PLANNING AMENDMENT

Application No. **H08/1106/95**
 Date Registered **14 DEC 1995**
 Case Officer **pu**

25, Clough Road, GOSBERTON RISEGATE

**Demolish existing buildings, erect new
 bungalow, garage and provide new access.**

Site Plan

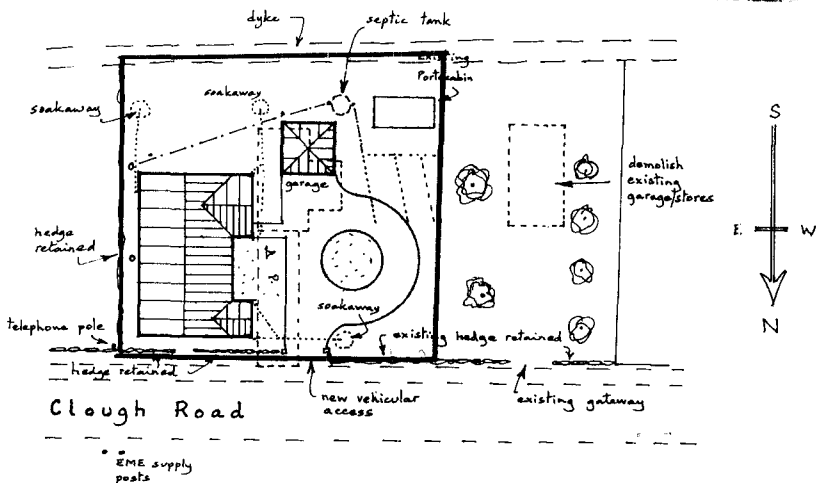
amended position of western boundary

Amendment Submitted: Amended position of western boundary

The amended details submitted in respect of the above proposal have now been considered, and I am able to inform you that there are no objections to the amendment being implemented to the extent described above.

Showing the revised position
of cross over and pedestrian access
as well as screening to frontage.
For: MRS G. R. Quinn

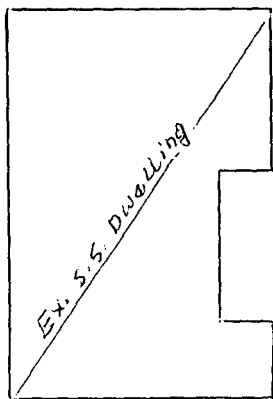
Amended access position

Amendment: Amended access position

The amended details submitted in respect of the above proposal have now been considered, and I am able to inform you that there are no objections to the amendment being implemented to the extent described above.
